18 February 2021

Your Ref: SSD-6966-MOD-1
Our Ref: R/2016/37/B
File No: 2021/050158

New Request for Advice – Barangaroo Building R5 Mod 1 Design Amendments – SSD-6966-MOD-1

### 2.1 Park Facade Shift

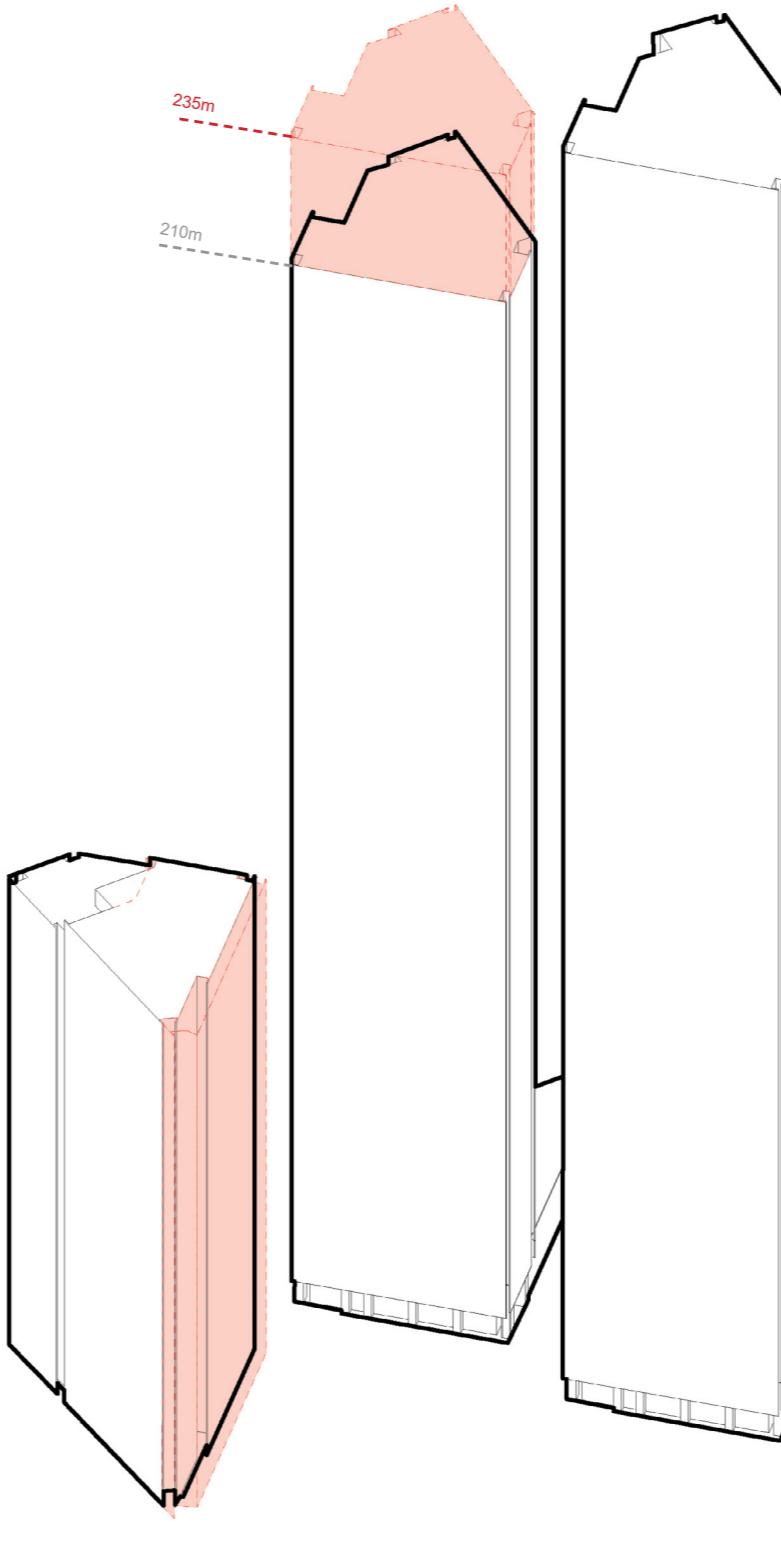
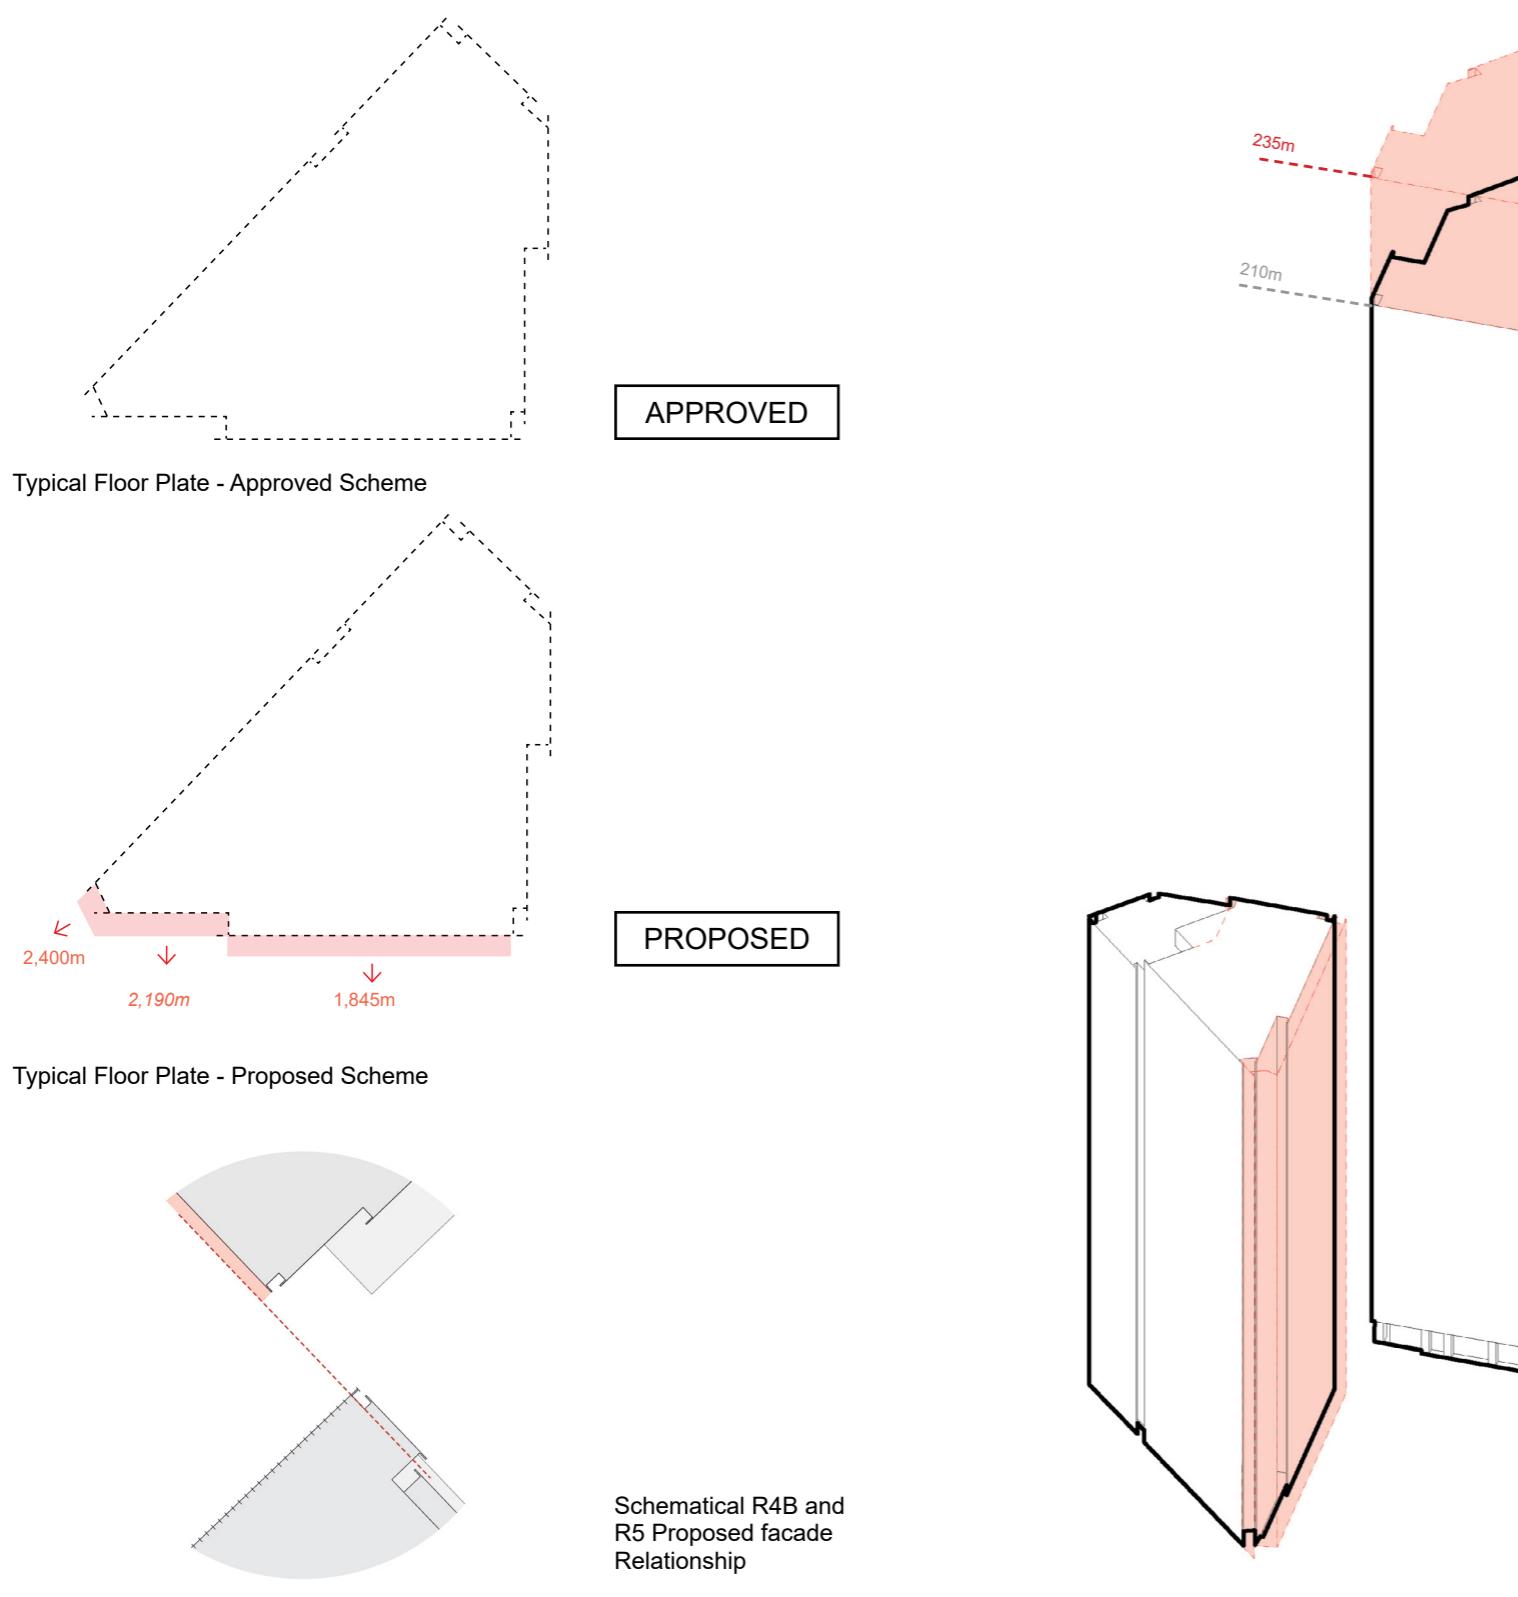
The proposed modification seeks consent to increase the glass line of the building to the north towards Hickson Park increasing potential impacts on the public park and the surrounding public domain areas. The submitted wind report shows inconsistencies with the application regarding the description of the proposed design amendments and makes reference to an outdated set of architectural drawings. It is unclear whether the findings of the report accurately reflect the proposed amended development and if there are any additional adverse wind impacts on the public domain. Further clarification is requested.

Additionally, the increased building bulk now appears to be inconsistent with the established 12-16m exclusion zones between the three residential buildings and the edge of Hickson Park as approved in the public domain works consent SSD 7944. The proposed skewed building line and increase to the bulk of the building impacts the approved consistent building line for residential buildings R4A, R4B and R5 and reduces public amenity by impacting circulation spaces at the ground floor plane. It is recommended that the applicant prepare a response as to whether the public domain works approval was considered in the preparation of this application and a justification for the encroachment into the established exclusion zone.

R5 Proposed apartment mix diagram.

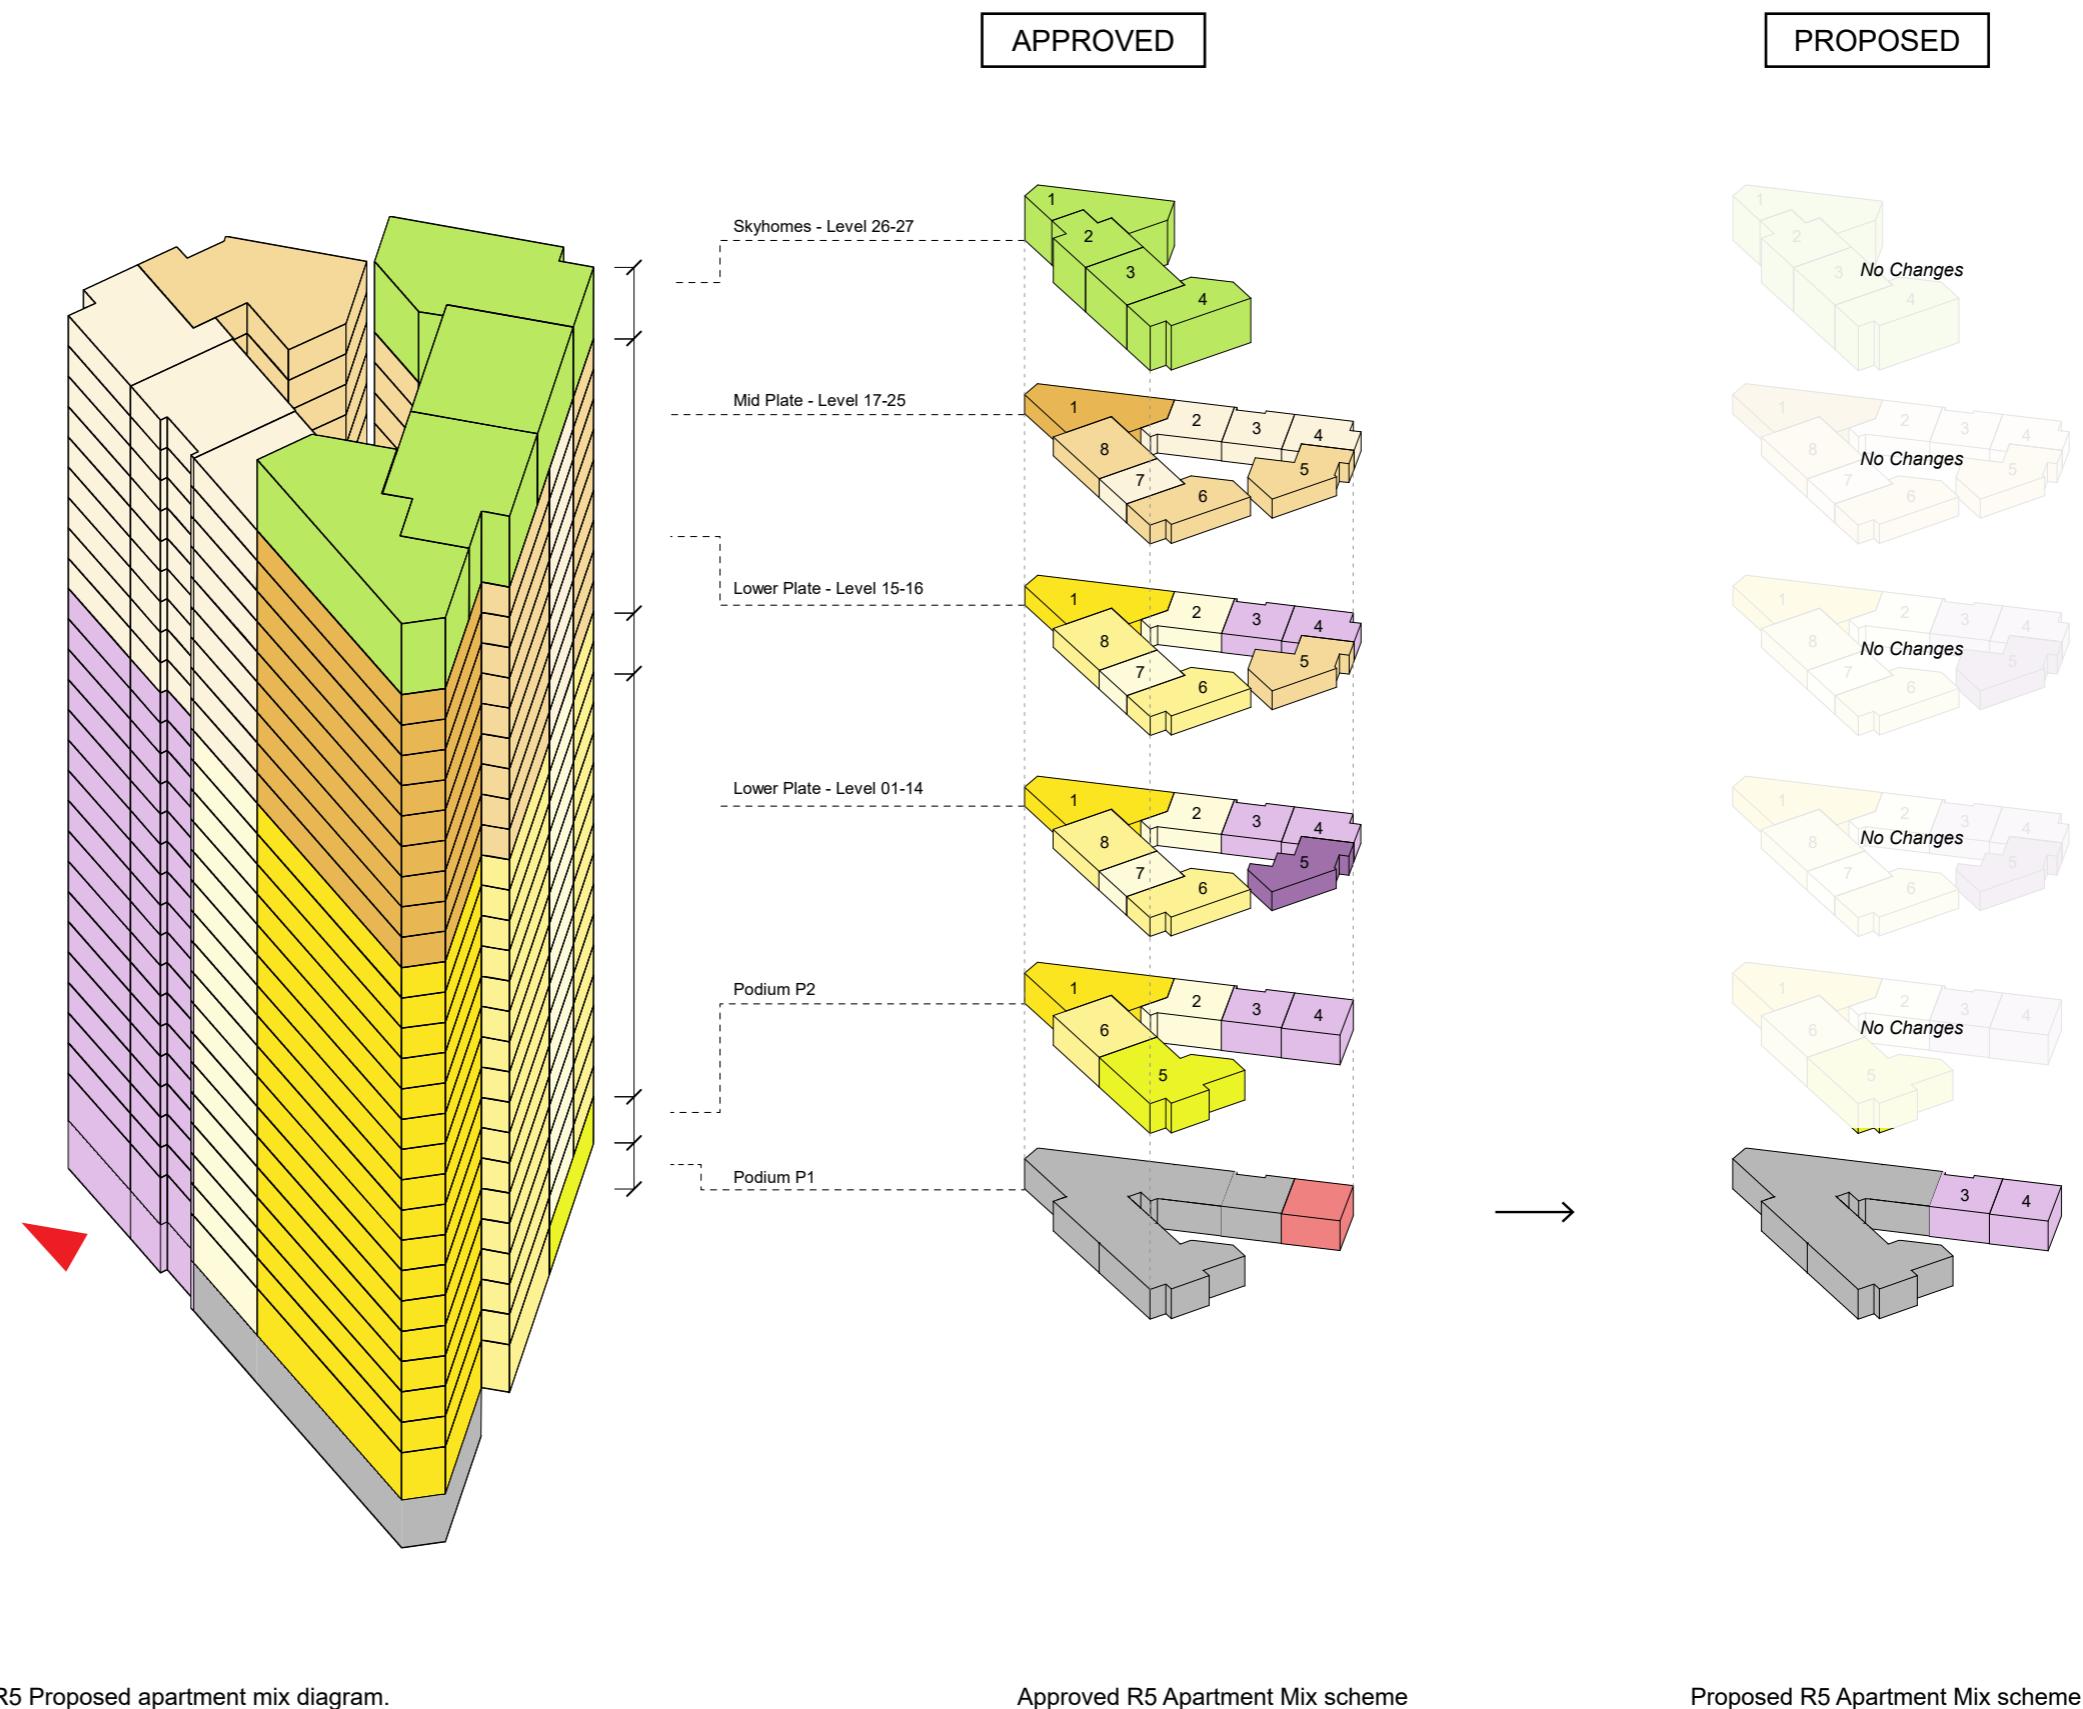
The City welcomes the proposed additional housing for key workers. However, the location of these apartments at Level 1 with few amendments to the apartment’s design will result in poor solar access to apartments and common open spaces, with approximately 75% of key worker apartments failing to achieve minimum solar access requirements. This further diminishes the provision of adequate residential amenity within the building for the key worker user group.

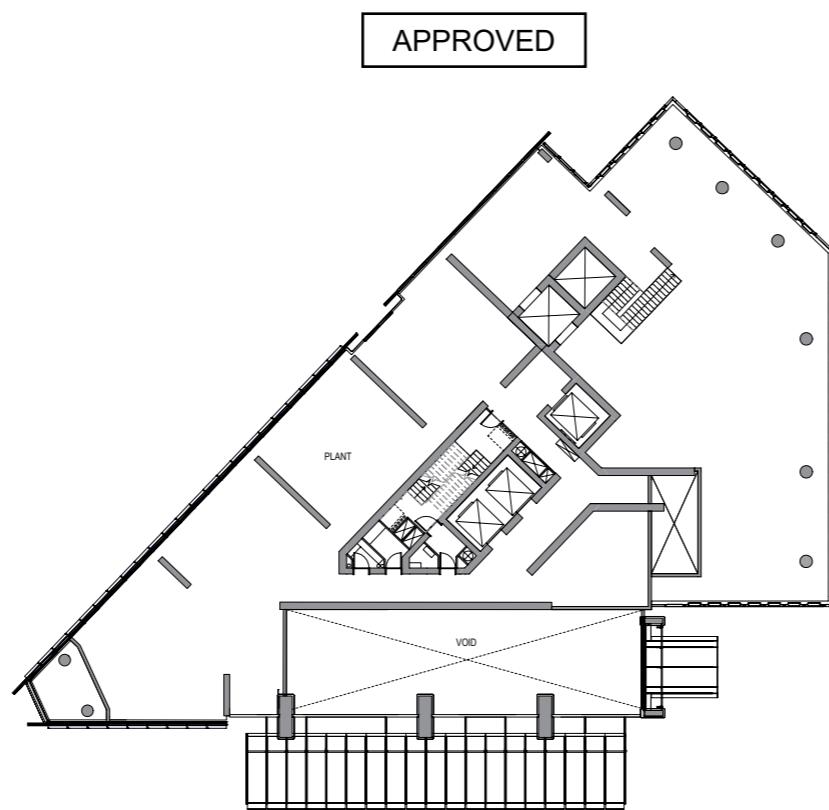
The application proposes amendments to residential apartments to accommodate additional studies and reconfigured layouts as a result of the proposed increased floor plates. The internalised studies are located at a significant distance from a natural light source, resulting in artificial lighting being required to illuminate the space and is inconsistent with ADG Objective 4D-2.

This issue is further exacerbated with the increased apartment plan depths which exceed 8m. This was raised as an issue in the City's previous objection and the additional apartments that now exceed this design criteria further reduce the environmental performance of the building. The design verification statement submitted with the application acknowledges the non-compliances and states the apartments achieve the design intent, however, the justification that the apartments are provided with full height windows and are open plan is not sufficient justification for the non-compliance and no further discussion is provided as to how the design intent is achieved.

Proposed P01 Plan

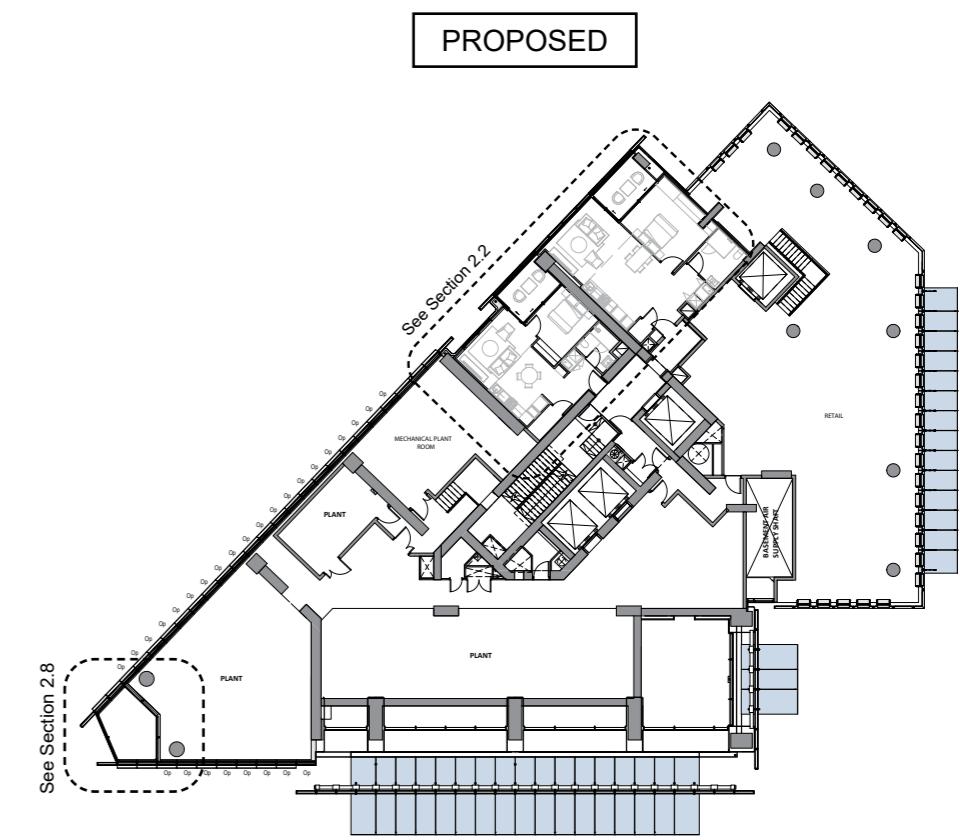
It is unclear whether the impacts of the location on Level 1 has been adequately considered, particularly regarding acoustic privacy and the proximity of apartments to noise sources on Hickson Road and surrounding uses. It is uncommon to find residential uses so close to the ground floor in a CBD context as they cannot struggle to comply with acoustic requirements. The submitted supporting written documents do not address acoustic compliance with parts 4H and 4J of the ADG.

A further issue is raised regarding the intermingling of retail and residential uses on Level 1. It is unclear why the retail use requires access to the residential lift foyer at Level 1 and clarification is requested. This is adding further pressure on the single lift core allocated to the key worker housing, approved to service 48 apartments and is inconsistent with ADG Objective 4F-1.

Overall, the proposed modification makes no attempt to increase the amenity of these apartments by further decreasing solar access compliance and restricting access to communal open spaces to an overshadowed terrace at Level 2.
